July 6, 2022

**WEC RESPONSES – 8/8/22**

**RE: Trailer Direct Express Rezone and Site Plan 2<sup>nd</sup> Submittal**

DEVELOPED DRAINAGE
TRAILERS DIRECT EXPRESS
18955 BEACON LITE ROAD
TOWN OF MONUMENT, EL PASO COUNTY, COLORADO

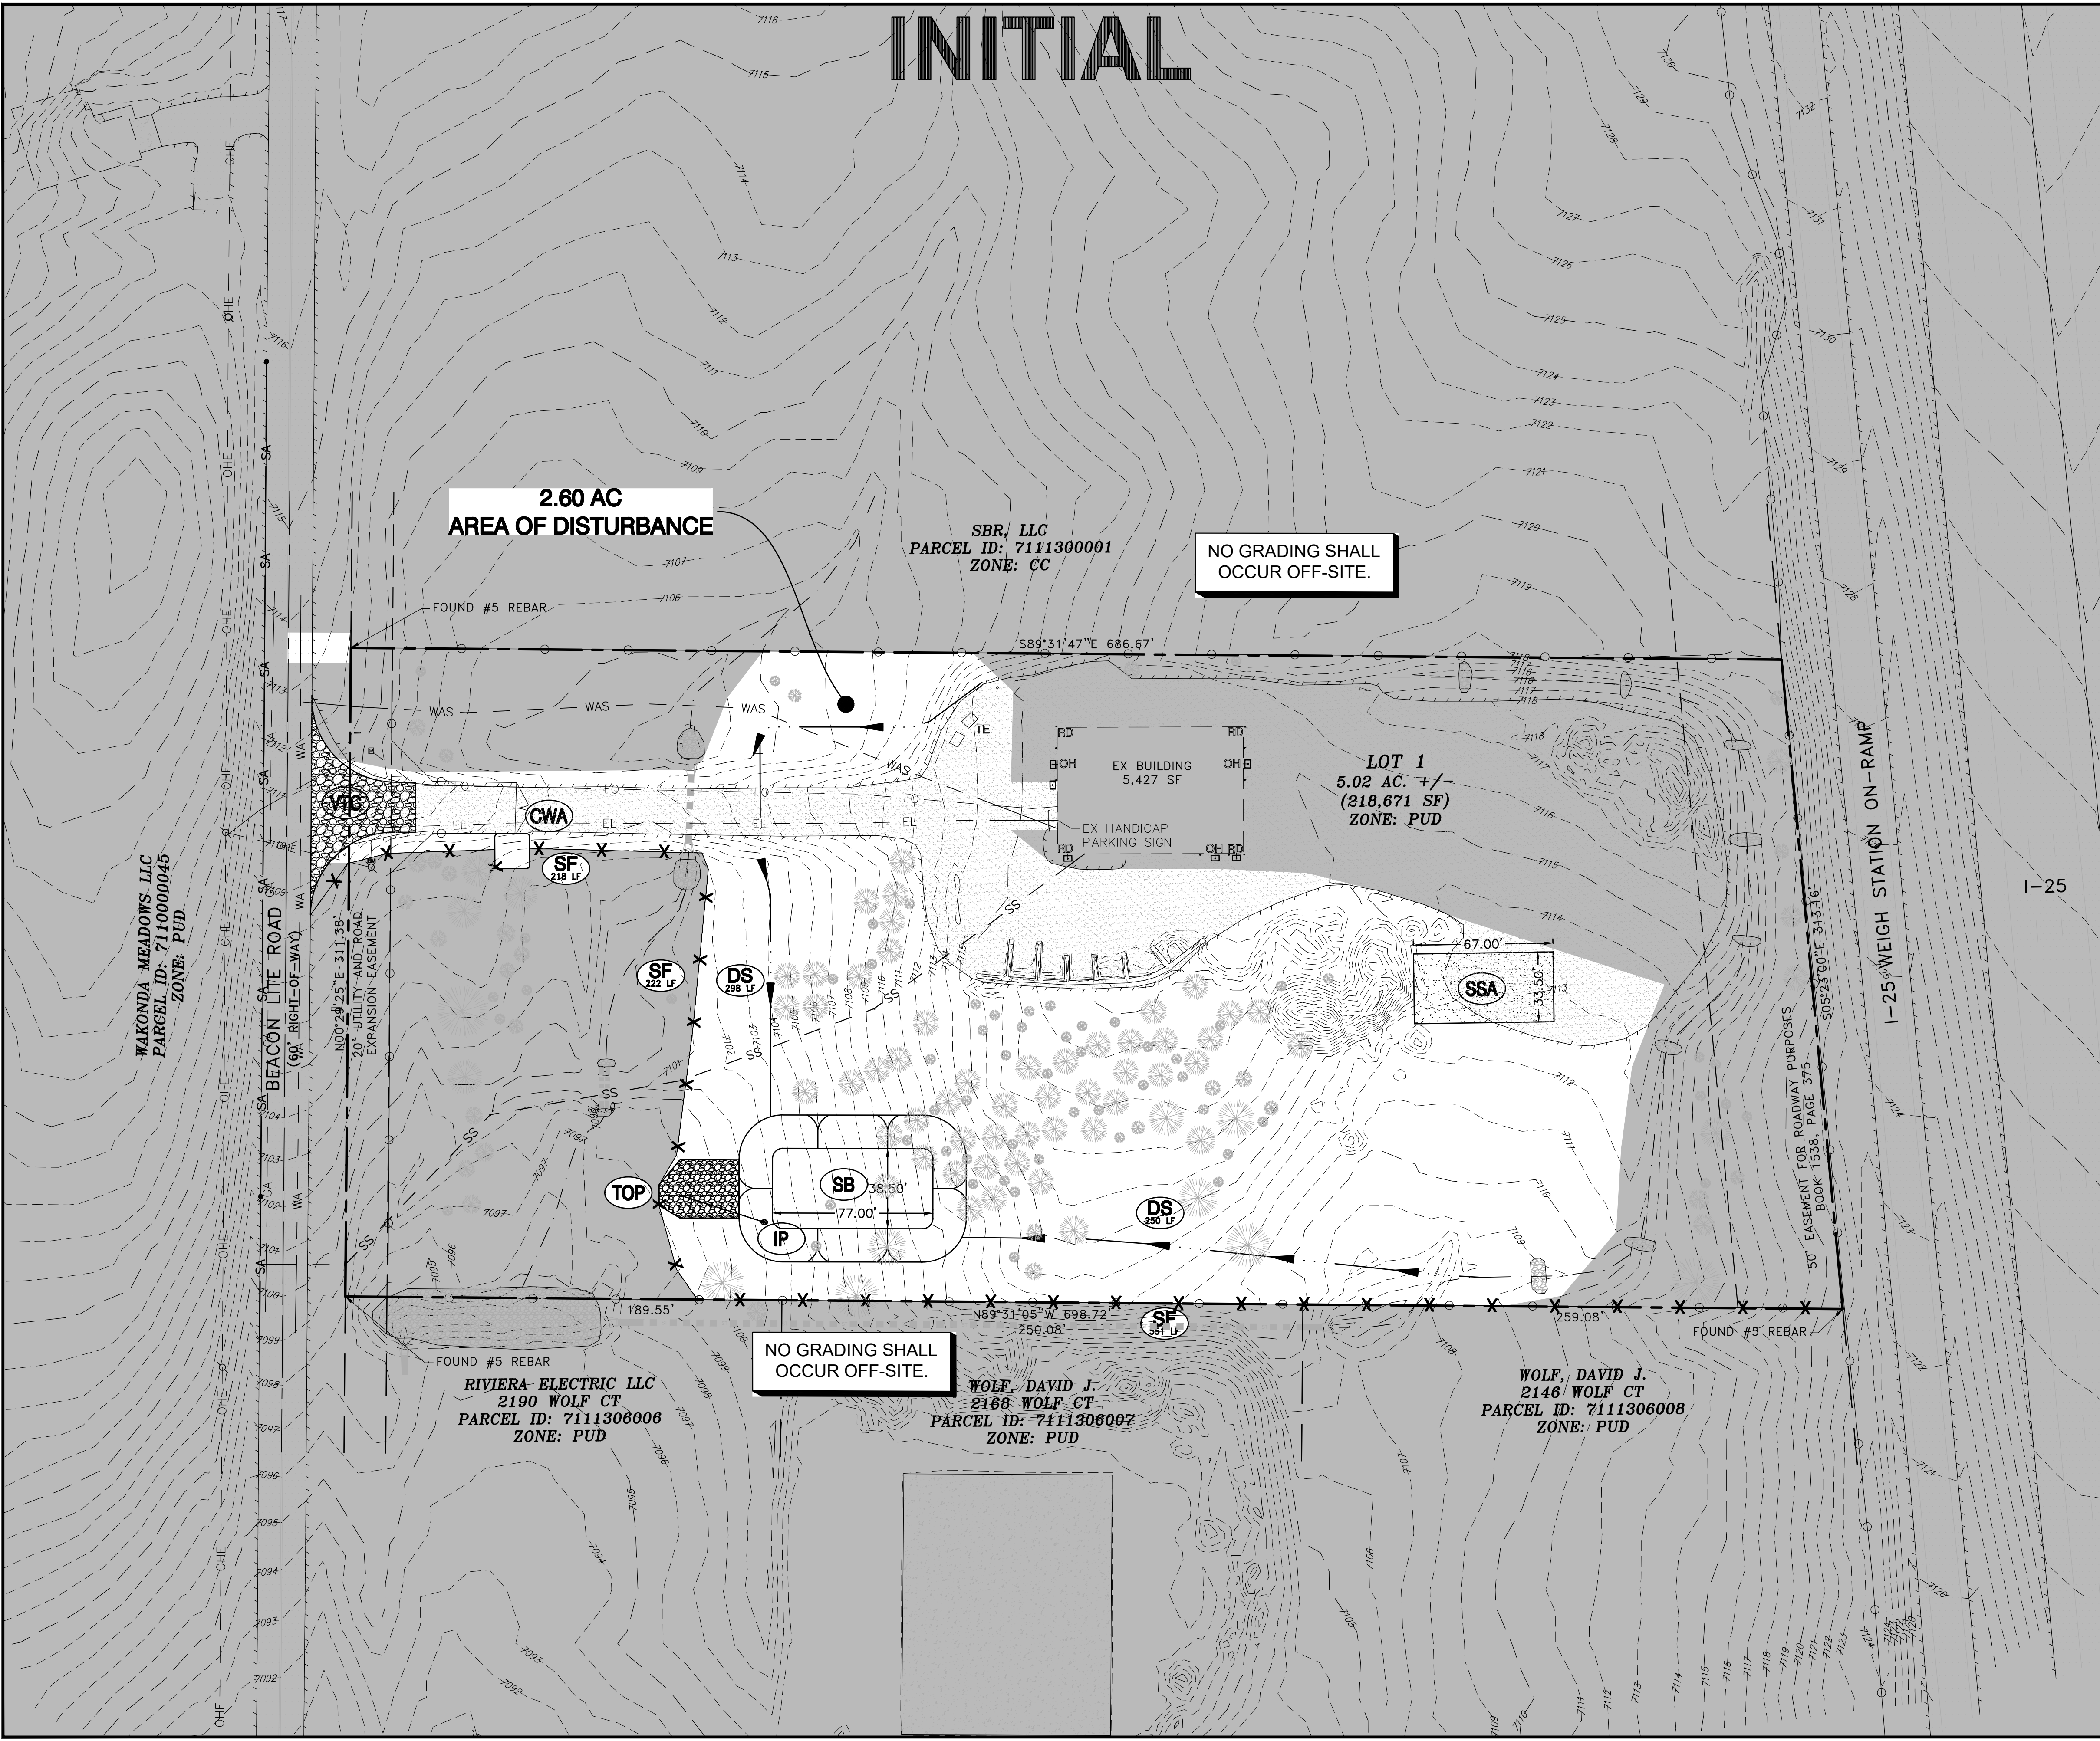
4. The minor/major storm runoff coefficients reported for the "S" basin should be coordinated between the Developed Runoff Table and the Developed Drainage Plan (Sheet 11). **Addressed**

EXISTING CHAINLINK FENCE DETAIL

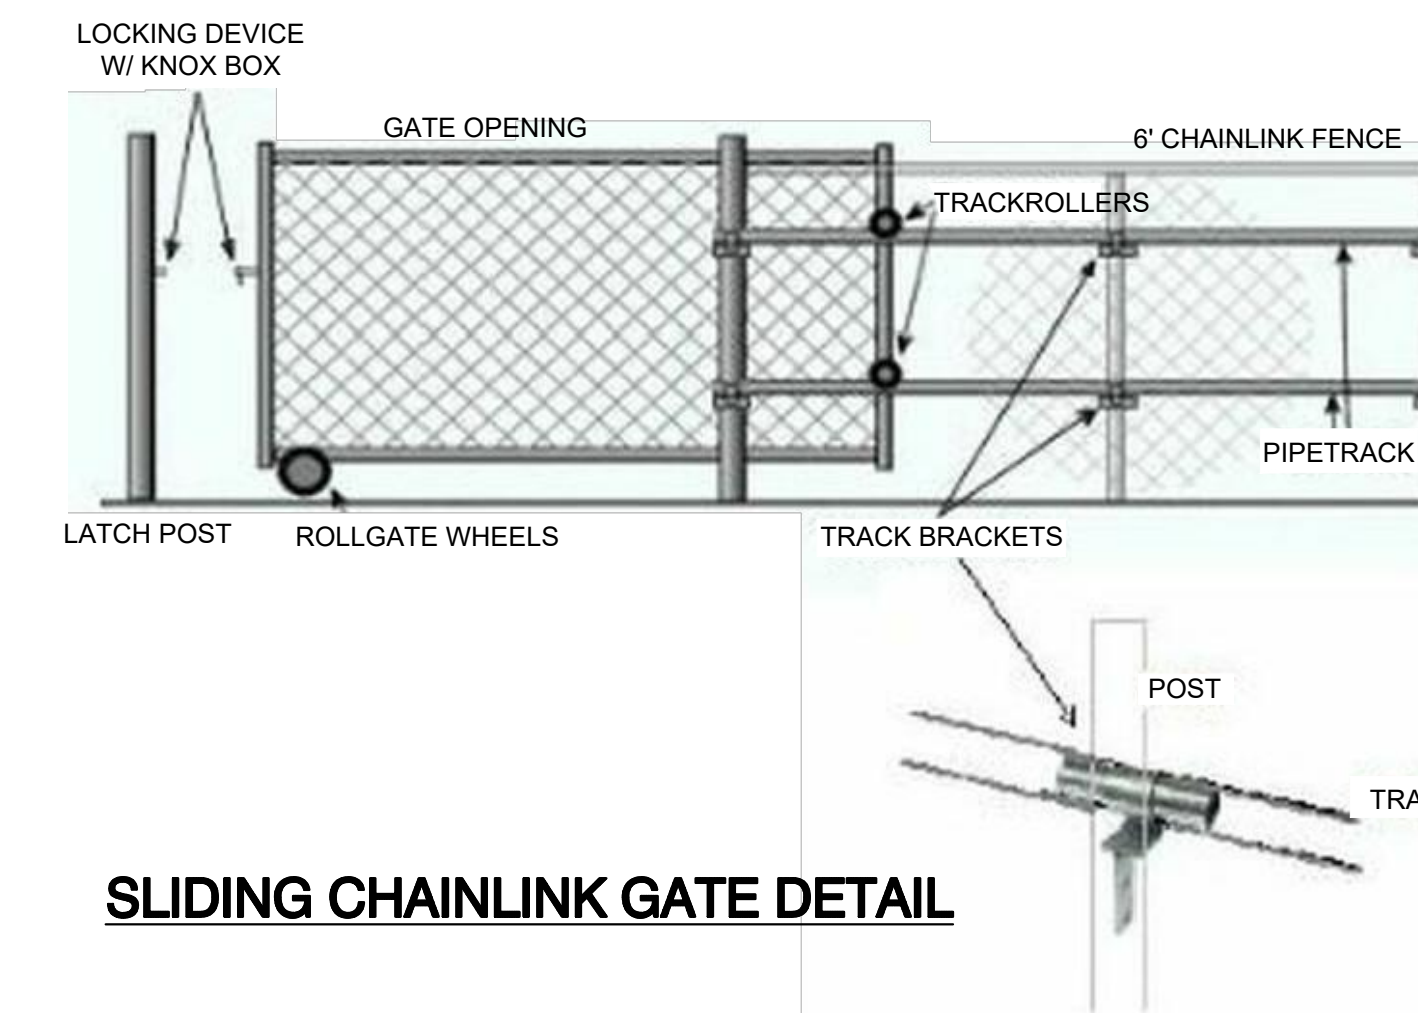
1. Please provide an opaque chain link fence detail rather than the existing fence detail.

3. Please revise screen chain link fence to opaque chain link fence.

*An opaque chain link fence detail has not been provided as a number of evergreen trees are to be used to screen the site and the site will be used to only store new trailers. Please see the attached email from the Town of Monument (Nina Ruiz) stating that the requirement for an opaque fence will not apply in this situation.*

*An opaque chain link fence detail has not been provided as a number of evergreen trees are to be used to screen the site and the site will be used to only store new trailers. Please see the attached email from the Town of Monument (Nina Ruiz) stating that the requirement for an opaque fence will not apply in this situation.*
